Bega Valley Health Services Hospital Development

SSD 5307 - 2012: Response to Submissions

December 2012

1 Plan Helipad-flight path
1 : 1000

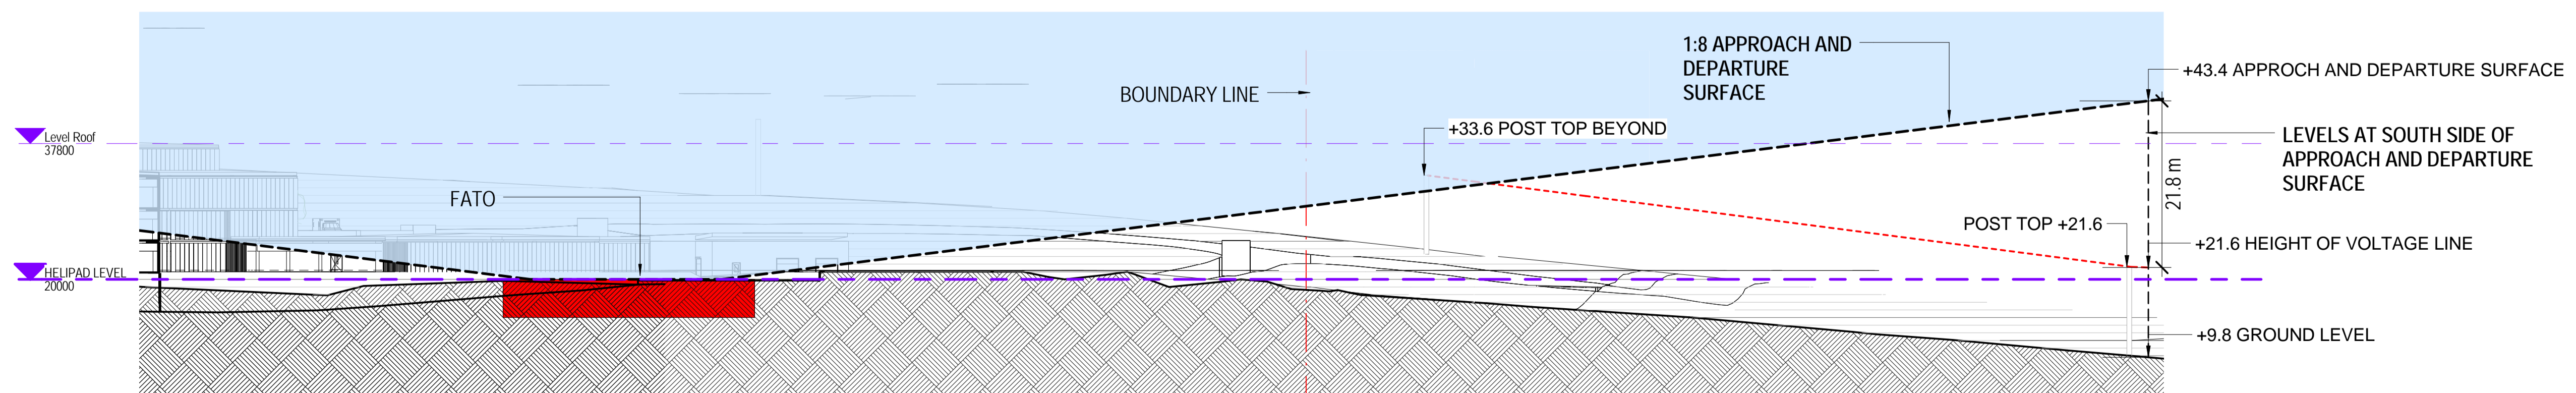
ISSUE	COMMENT	RESPONSE
	<i>indicated currently to the north could be relocated to access the site from the north east, across mainly agricultural zoned lands. Prior to finalisation of the flight path, consideration of this alternative by the proponent should be requested.</i>	The proposed flight paths require a 150 degree separation between the paths for safety reasons and as such there is no opportunity to amend the flight paths. NSW Health Infrastructure notes that the flight paths currently traverse rural zoned land, much of which is below the 1 in 100 year flood level. Helicopter movements are expected to average between 5 and 10 per month, based on current movements from Bega and Pambula hospitals.
Bega – Tathra Road Speed Environment	It is noted that, in consultation with Roads and Maritime Services, the speed zone along Bega-Tathra Road is proposed to be altered to a 60km/h zone to encompass the new roundabout only. Council strongly believe that the 60km/h speed zone should be extended further south past the intersection of Bega-Tathra Road and Boundary Road. There is an existing dairy farm which utilises the eastern leg of Boundary Road and as a result there are movements by slow moving farm machinery often at this intersection. Concerns were raised by Council in discussions with the proponent's consultants SKM and the RMS during the preparation of the Transport Assessment. Maintaining a 100km/h speed zone in this location, with the proposed increased traffic generation of the regional hospital, would likely increase the risk of collision at this intersection. In assessing this proposal, it is considered critical that the speed environment at this dangerous intersection be reconsidered and a pro-active approach be taken to minimise the risk of serious injury or fatality.	NSW Health Infrastructure supports the initiative of BVSC to reduce the speed limit to 60 km/hour along Bega – Tathra Road. However, this does not appear to be relevant to this application at this Stage.
